Subject: RE: Attached letter from Kirklees Council regarding application number 2025/92836 at location The Priory, Whitechapel Road, Cleckheaton, BD19 6HR

Condition 14- security measures:

Condition 15- boundary treatments

Condition 16- lighting:

Street Lighting

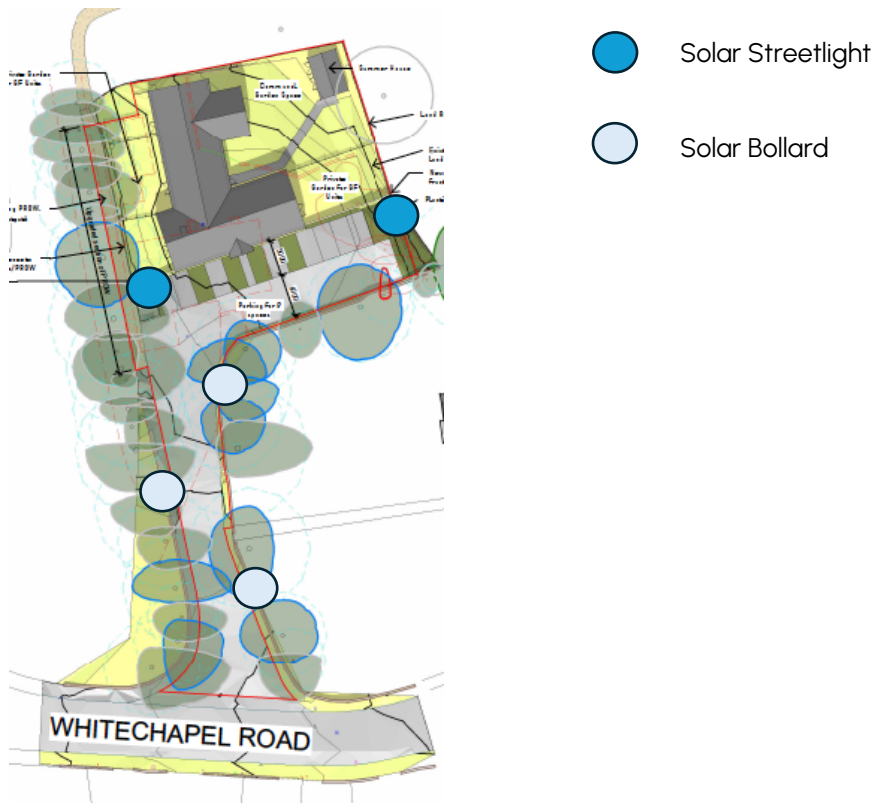
Street lighting controlled by PIR sensors is not supported from a crime reduction perspective due to operational inconsistency. Additionally, such lighting can increase the fear of crime due to false activations. It would provide sudden bursts of light rather than contribute to lighting uniformity during the hours of darkness. This solution would also be likely to hinder the quality of CCTV footage onsite in those times- the parking provision is included in the coverage, as mentioned in the Crime Prevention Statement. With the car park likely occupied at night by staff members' vehicles, street

lights should provide a constant level of illuminance rather than motion triggered, short bursts as this will reduce surveillance and may give offenders an opportunity to work undetected.

Bollard lighting is not recommended either as it does not project a sufficient level of light at the right height and can be easily obscured or damaged.

Additionally, will solar powered street lights perform satisfactorily in autumn and winter months when sunlight can be sparse?
